FERRING CRICKET CLUB

Little Twitten, Sea Lane, Ferring, West Sussex

Application FG/174/17PL

DRAWING TITLE
Proposed Site Plan, Location Plan
and elevation from south

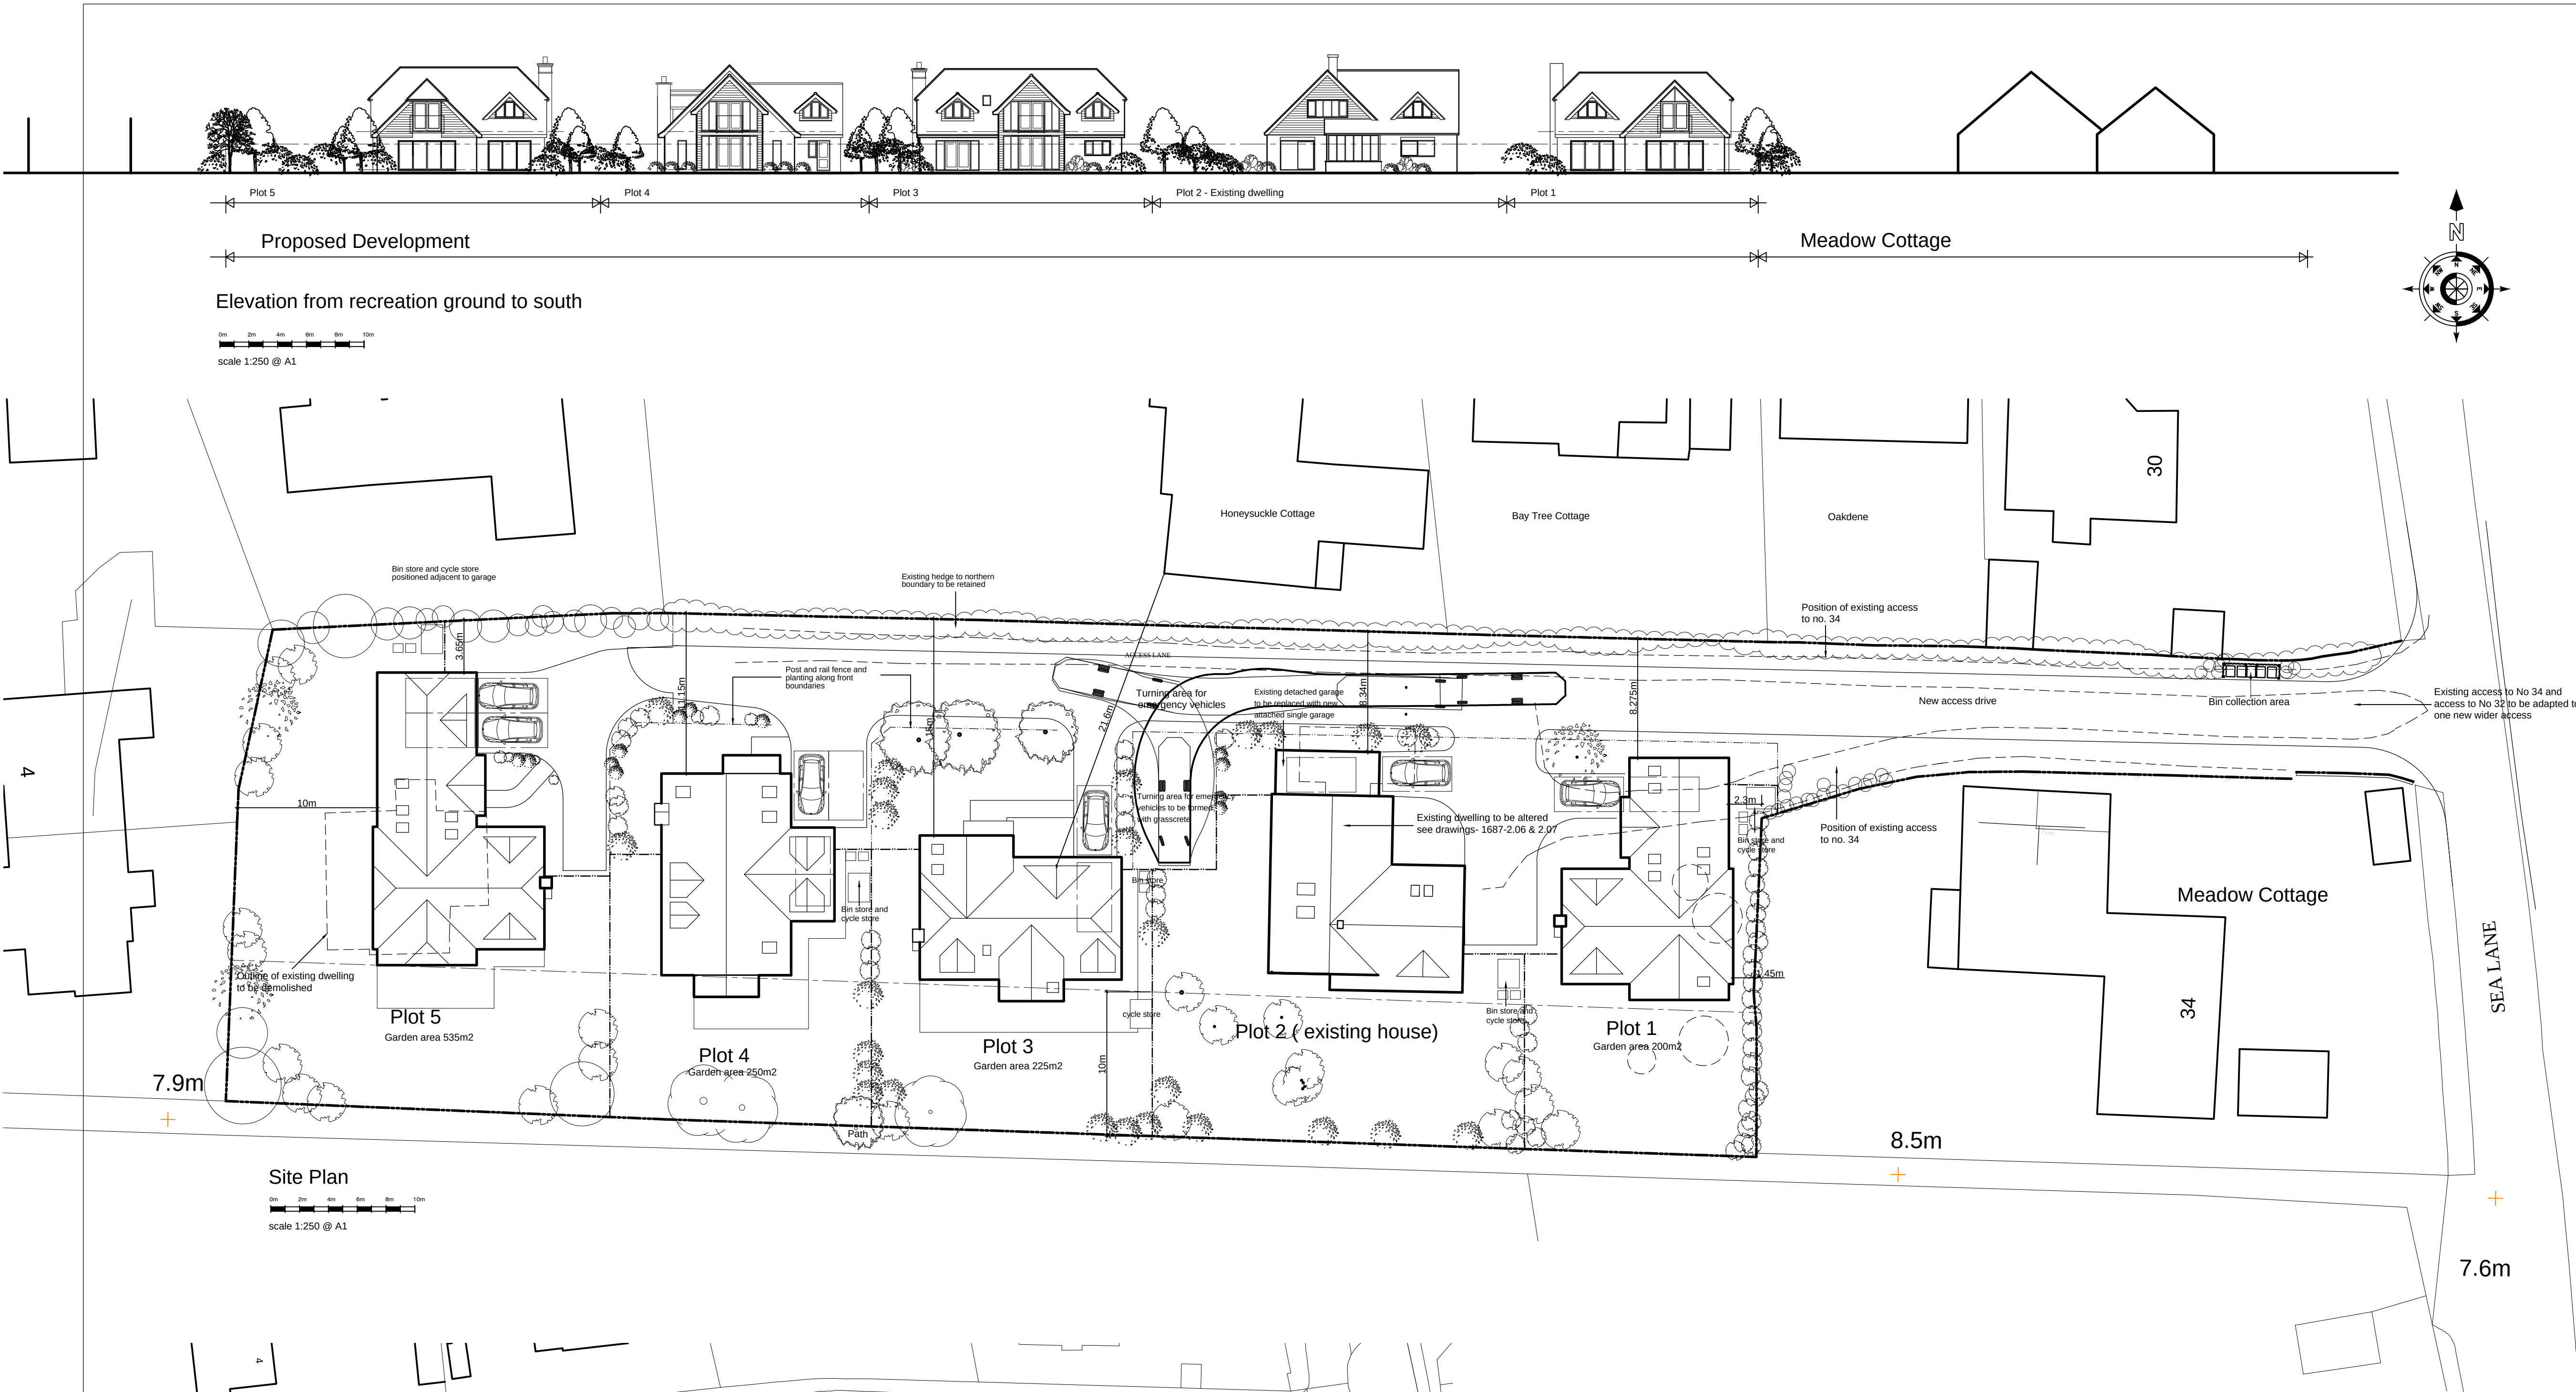
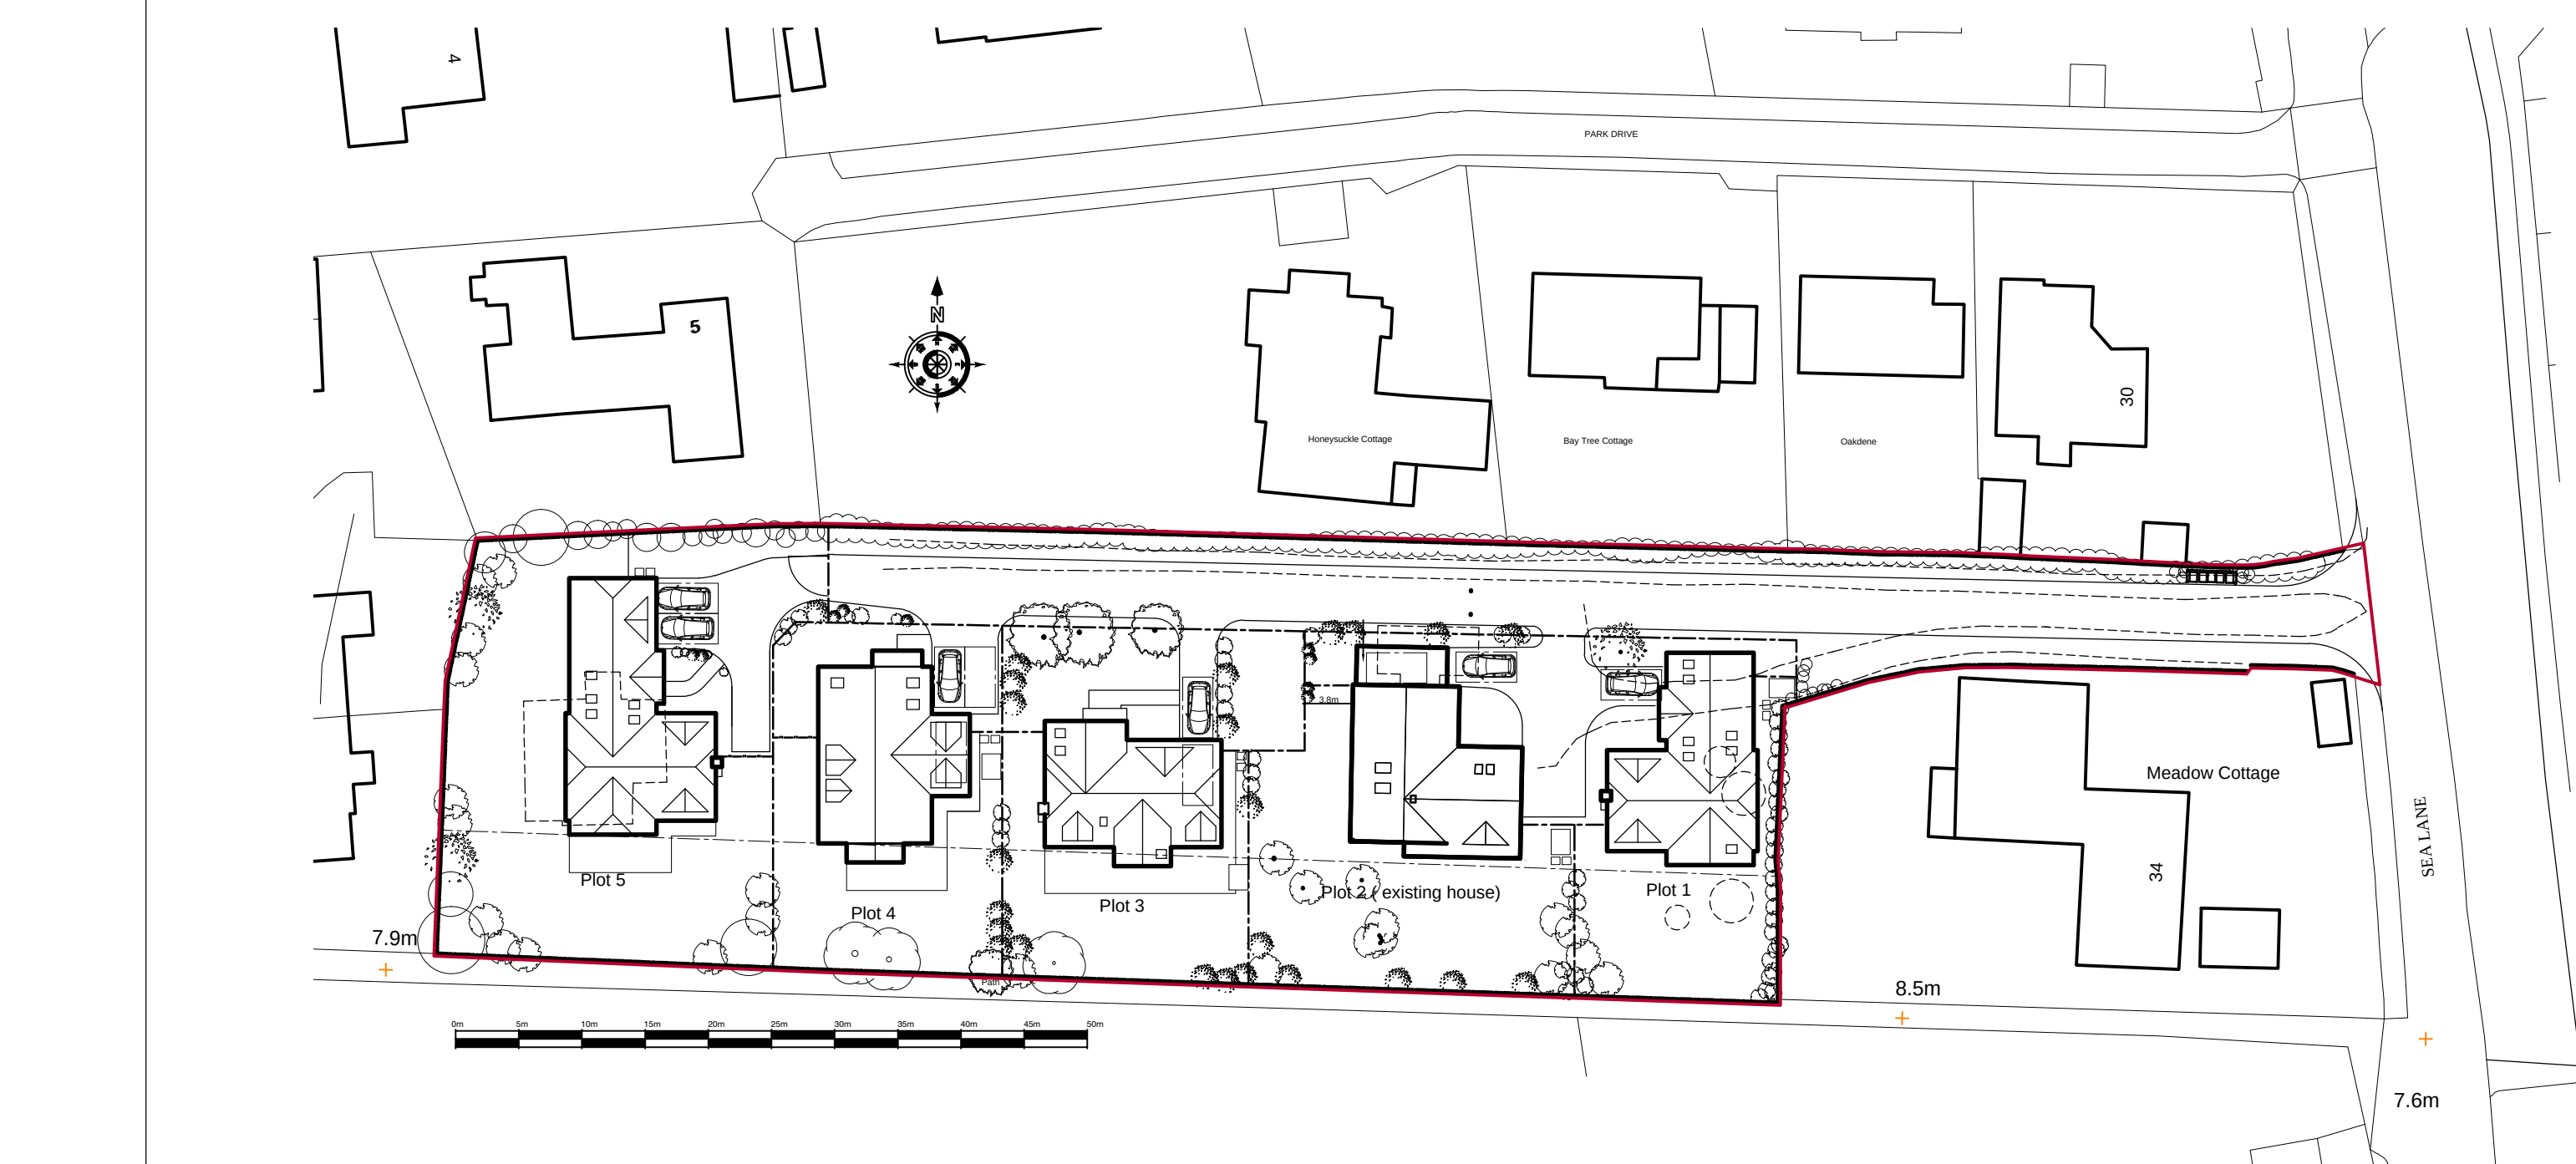
The removal of all the mature trees and hedge screening by the land owners has greatly increased the exposure of three of the proposed properties to the ingress of cricket balls into gardens, with the associated danger to property and families, particularly children.

We therefore urge the local Planning Authority that as a condition of any planning permission the developer be required to erect protective netting of a height and adequacy to prevent or limit cricket ball intrusion.
